Our Case Number: ABP-317560-23

Lacknaslieva,
Enniscrone,
Co. Sligo.
13th May 2024

*RE: Proposed windfarm development including 13 no. wind turbines in Bunnyconnellan,
Co. Mayo and hydrogen plant in Castleconnor, Co. Sligo. Case number 317560-23*

Joe Queenan,
County Councillor
Sligo County Council

Figure 15.12: Junction Turning Movements at N59 / L-1102

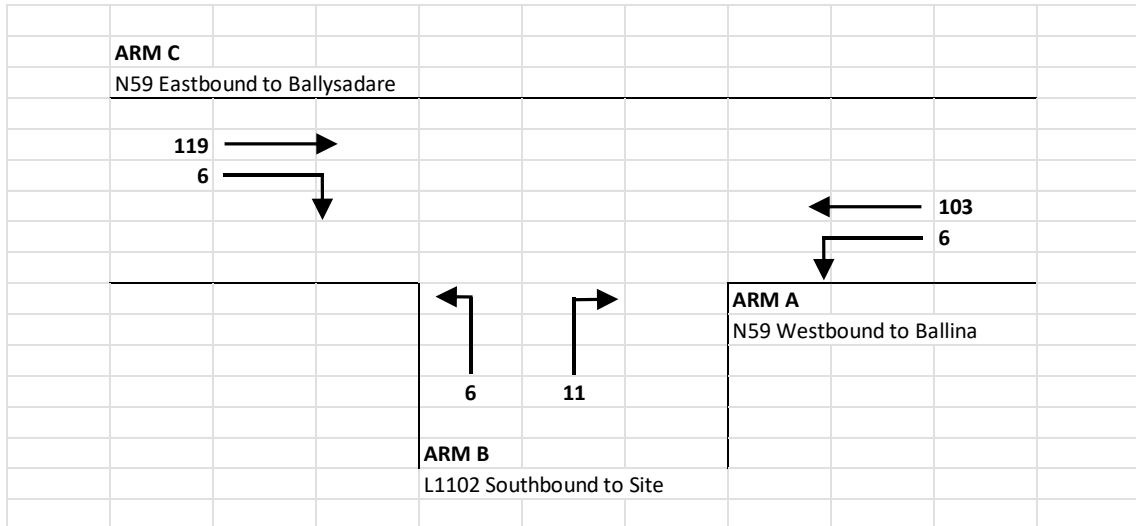
I am particularly concerned about the junction of the L1102 with the N59 at Corbally, where a large volume of all return traffic from the wind farm will be exiting the L1102 onto the N59 against all of the haul traffic travelling on the N59 to the wind farm site en route to the L6612.

Figure 15.13: Junction Turning Movements at N59 / L-6612-1 – AM Period

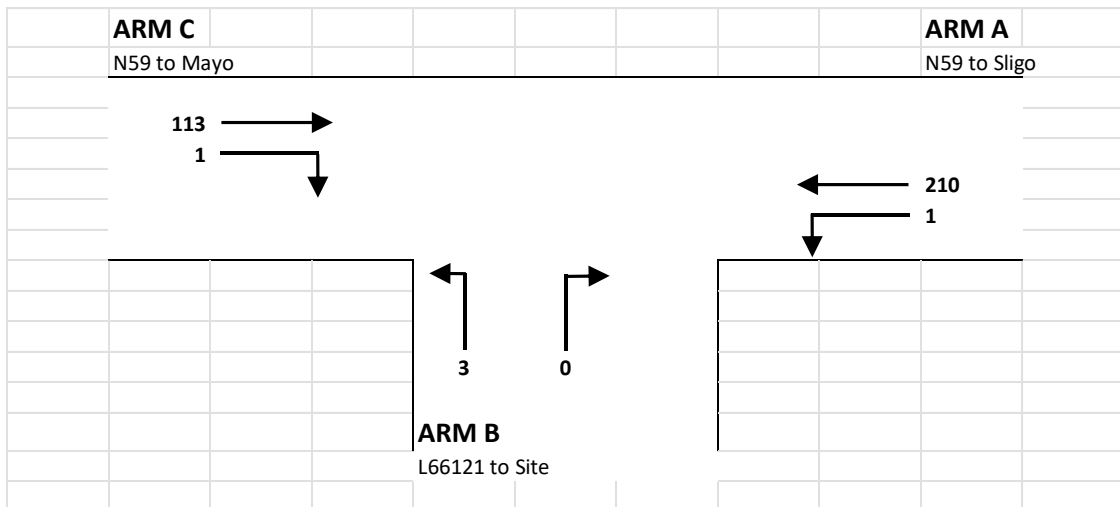
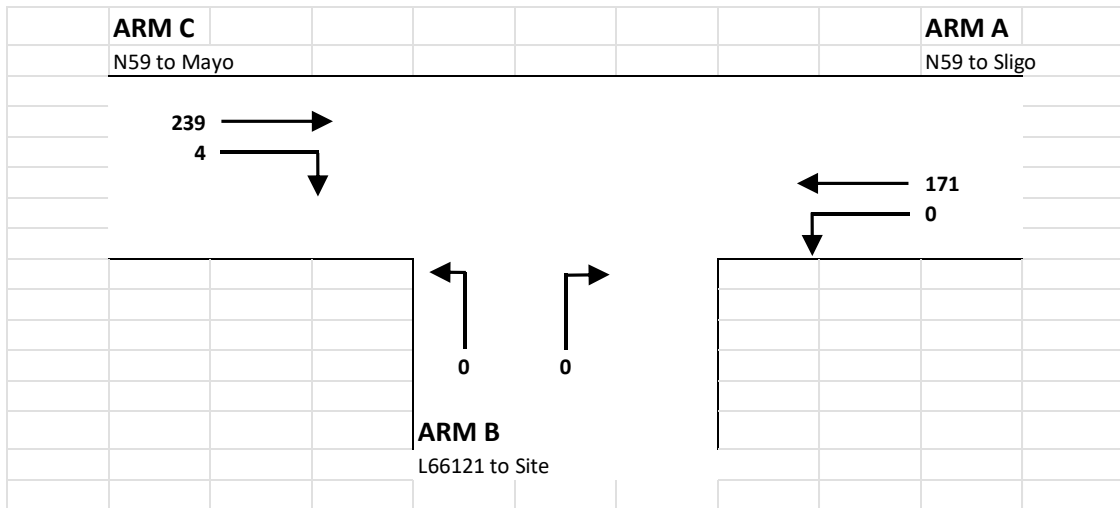
2. I am concerned that extra traffic that will be entering and exiting the Hydrogen plant site during the operational phase, at the L66121/ N59 junction. Have the farmers and other local users who already use this junction been taken into account? A traffic count was done when the farmers are least active on the roads. The N59 is a very busy road and additional trucks entering and exiting the junction at this point are a huge problem for me, particularly in light of the existing limitations set down by the TII for other landowners along the N59.
3. I reiterate concerns raised by me at the Sligo Co. Council meeting on 4th September 2023, about the large amounts of water to be extracted for the production of hydrogen.
